From: Martyn White
Sent: 11 December 2018 17:20
To: Planning.Responses
Cc: Amber Willard
Subject: WA/101/18/HH & WA/102/18/L

WA/101/18/HH & WA/102/18/L

The application is for the provision of a two storey extension, along with a new detached garage to be located within the front garden area.

Site Plan at 1:500 scale

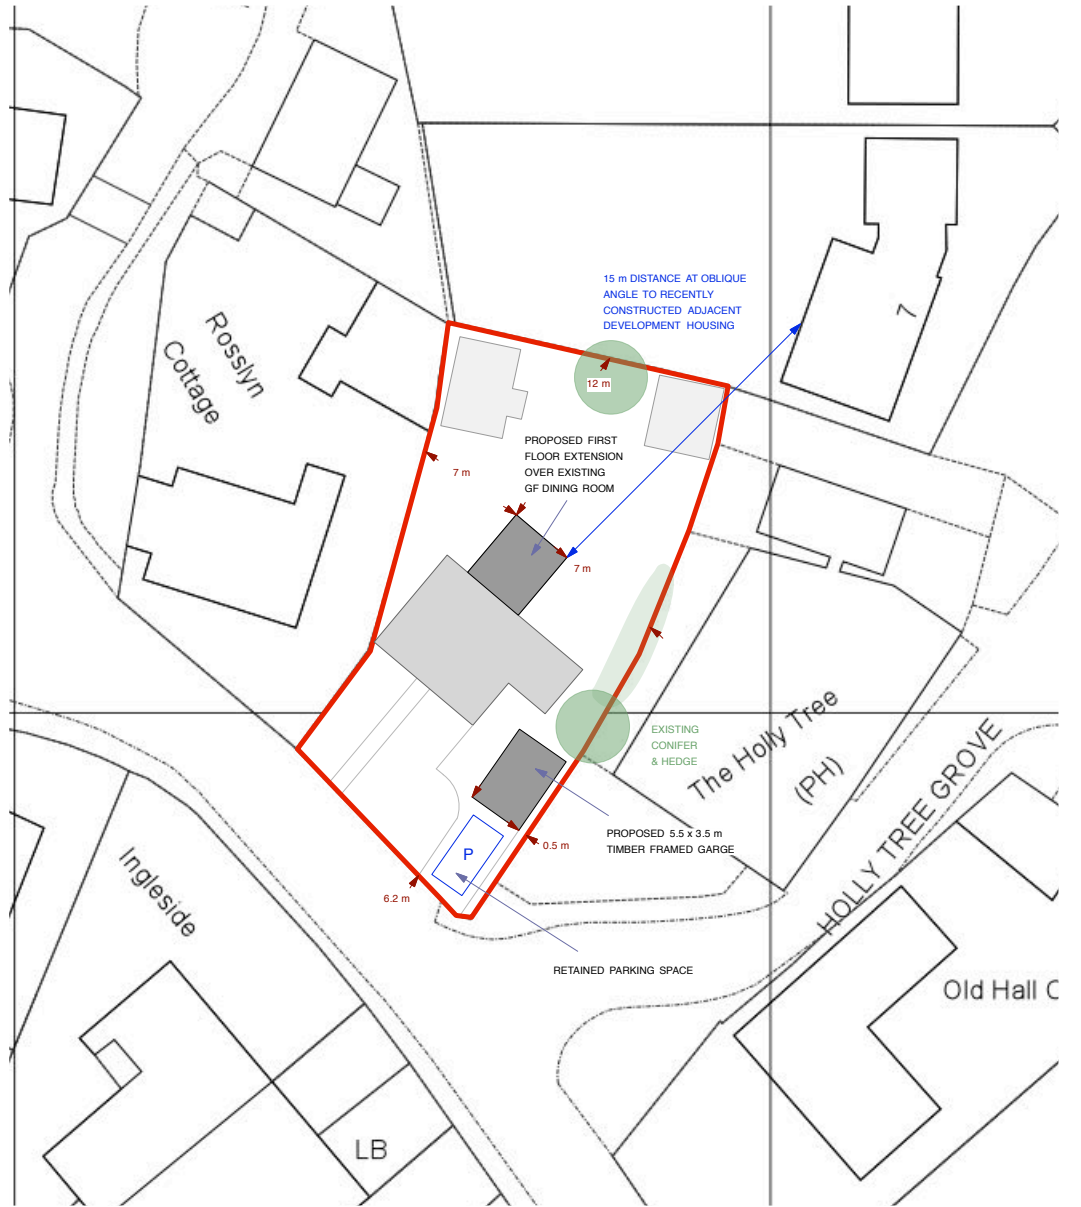
The proposed garage would essentially be built forward of the front elevation of the cottage on part of the existing parking area. At present the front garden area is contained by the flint wall and mostly laid to lawn with a small parking area for the resident's private car. Therefore, at present the cottage is fully visible from the street, and forms a focal point.

Development of the garage in this particular location will mean that it will play a dominant role in the street-scene and essentially block views of the listed cottage, so that only part of it is visible when looking westwards.

Further, the garage would be the only garage structure of this design, in this location in the conservation area. It is thought that out buildings are mostly masonry in construction, and therefore the proposed garage is of a conflicting design.
